PLANNING APPLICATION CONSULTATION RESPONSE

Application Number:	3/2023/0465
Proposal:	Erection of one new dairy cattle building with underground slurry tanks, associated hard standing and solar panels to south facing roofscape, removal of redundant metal ring slurry store and erection of two concrete slurry tanks with canopies.
Location:	Black Moss Farm Elmridge Lane Chipping PR3 2NY

The Lead Local Flood Authority **objects** to the above application on the basis of:

Objection 1 – Inadequate Surface Water Sustainable Drainage Strategy

Drawing
Proposed Surface Water
Drainage Layout

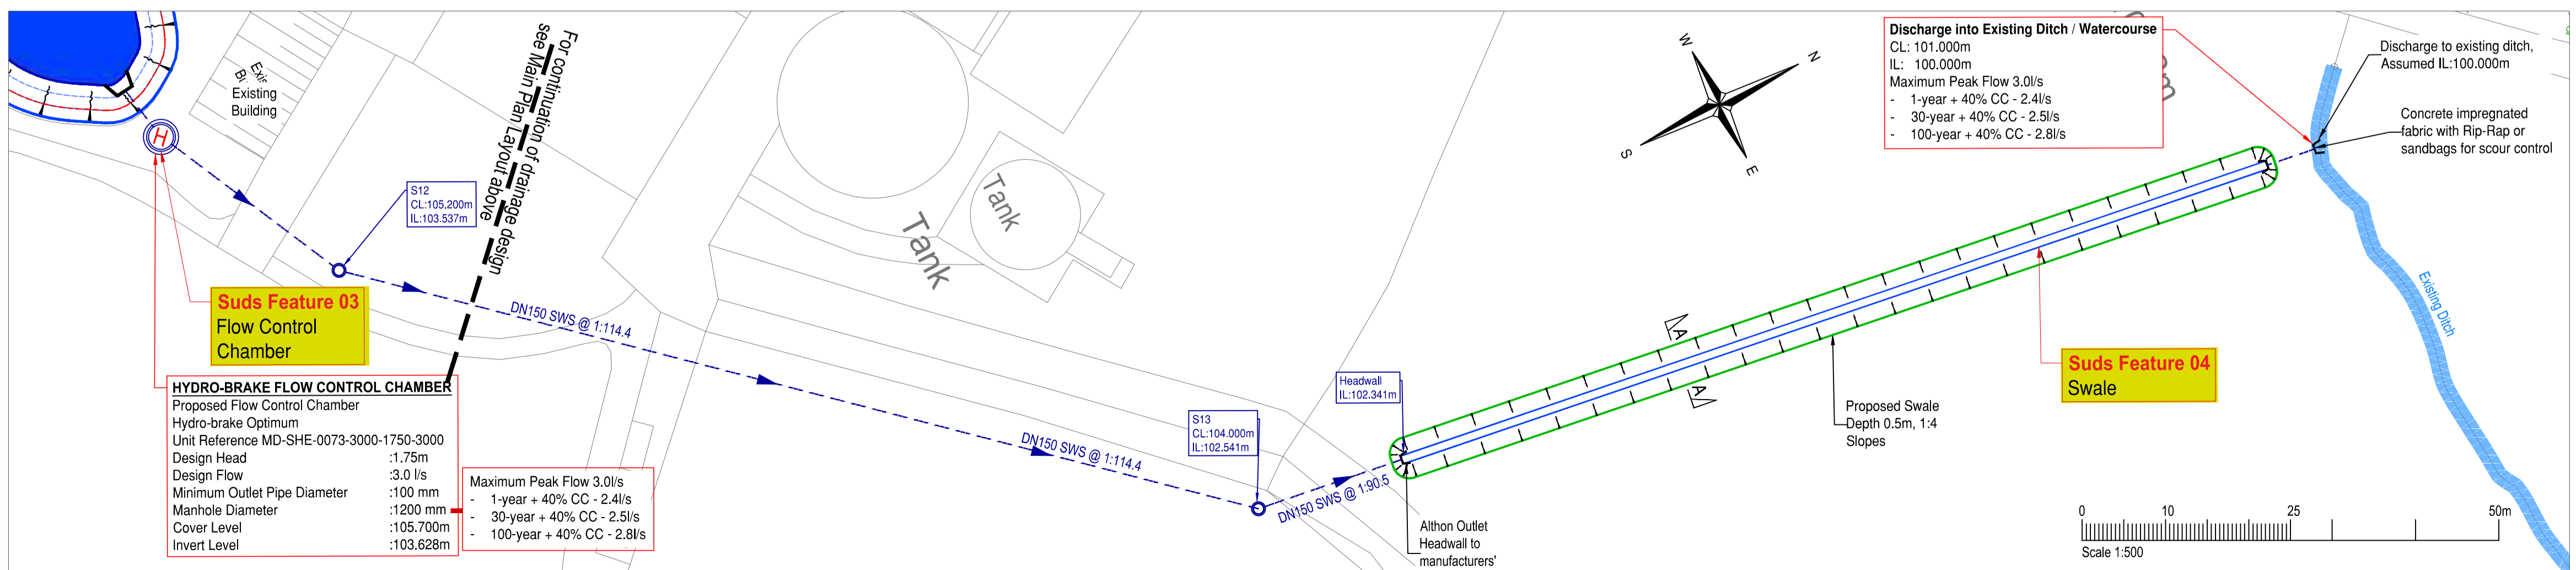
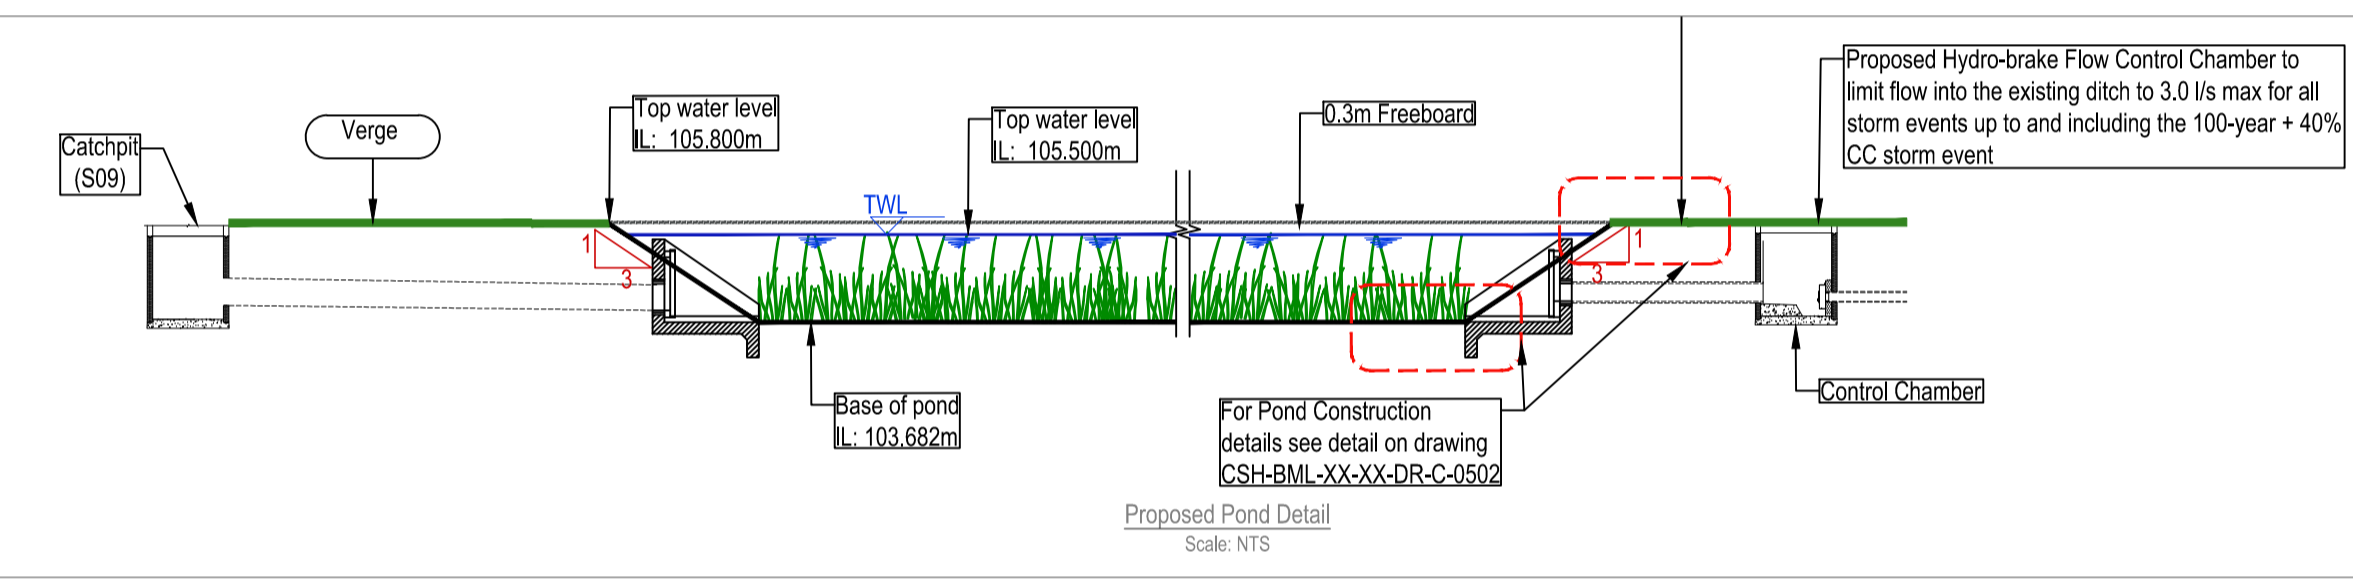
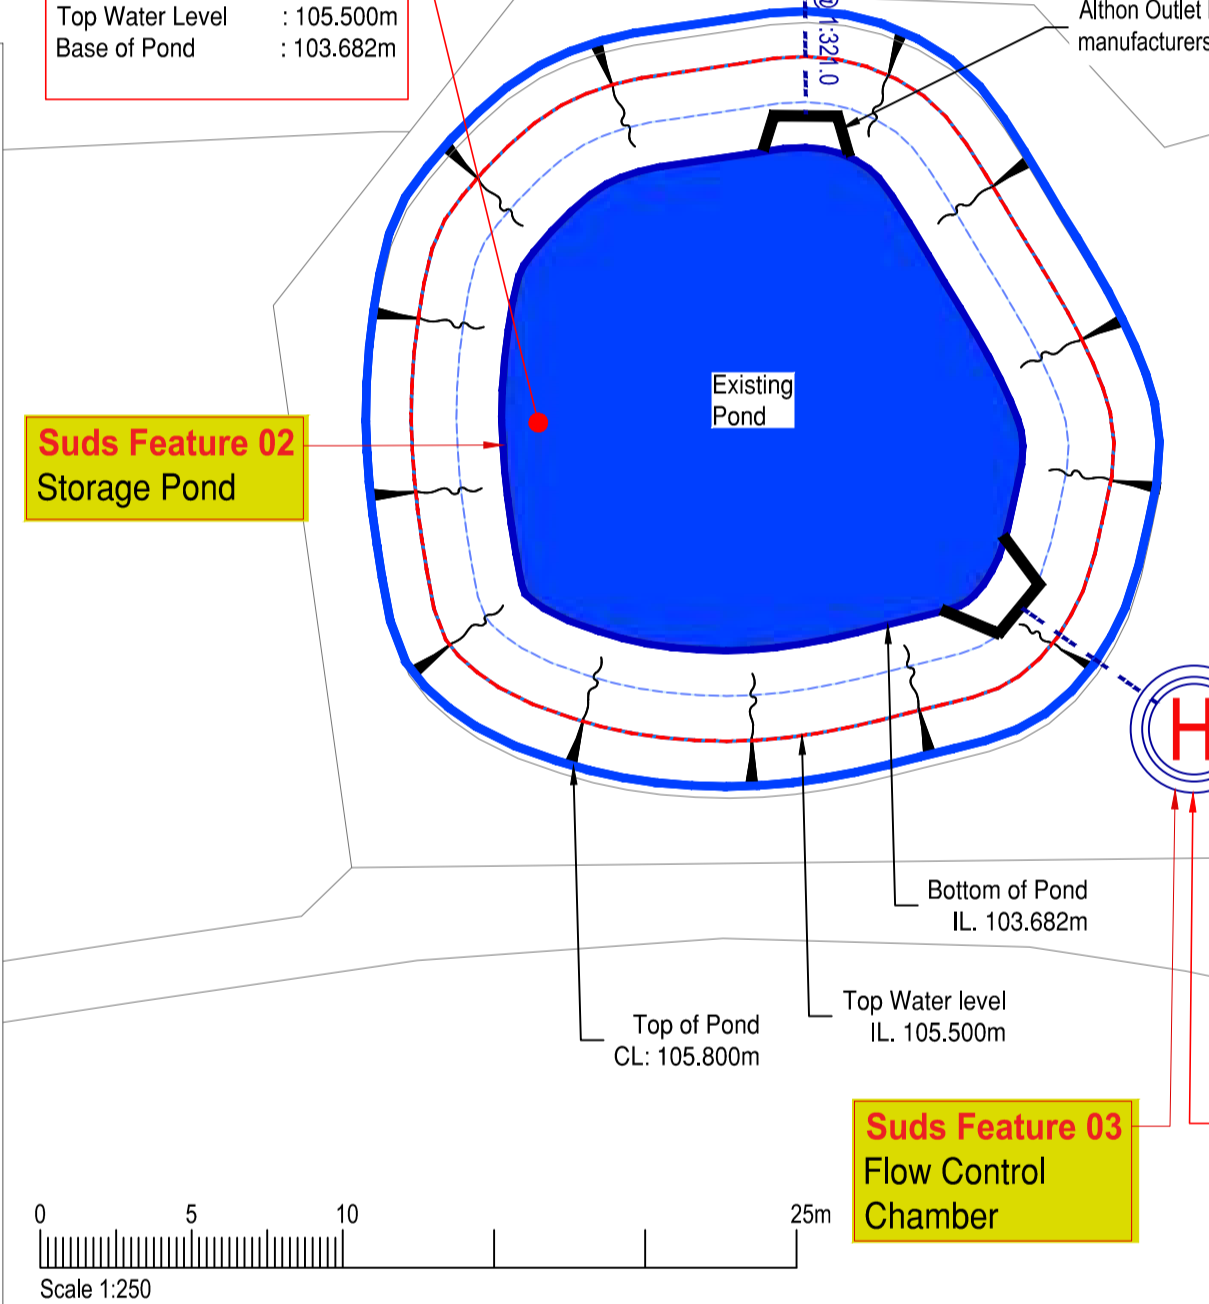
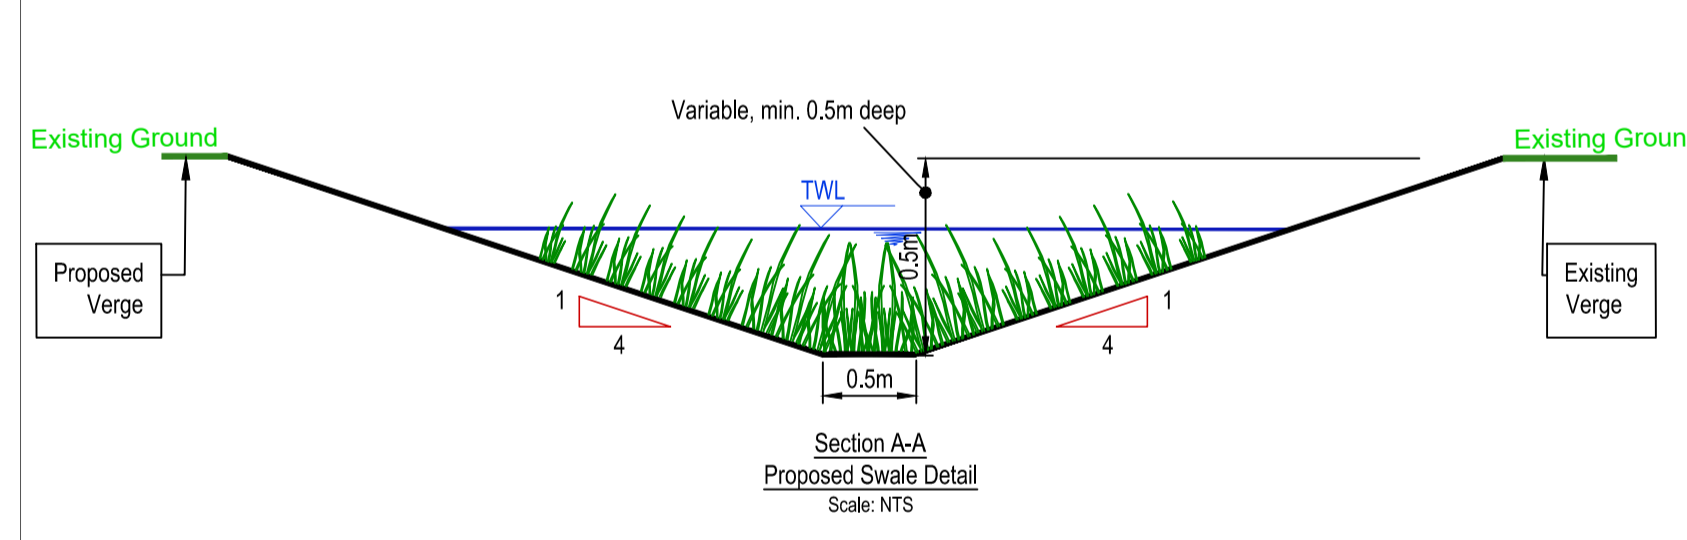
The applicant has proposed to discharge surface water from the development via an existing pond that is to outfall to a watercourse, the applicant has failed to provide information as to the location of this existing watercourse. Furthermore, given that the pond is existing, the applicant is expected to provide evidence as to the suitability of the pond for storing surface water post development, given the conversion of greenfield to impermeable area.

In addition to this, the drainage proposals only depict surface water post development being managed for the cow shed area of the development and not for the slurry tank area of the development, given that this area also is for the conversion of greenfield to impermeable area, the applicant will be expected to demonstrate how surface water will be managed within a drainage system for these new impermeable area.
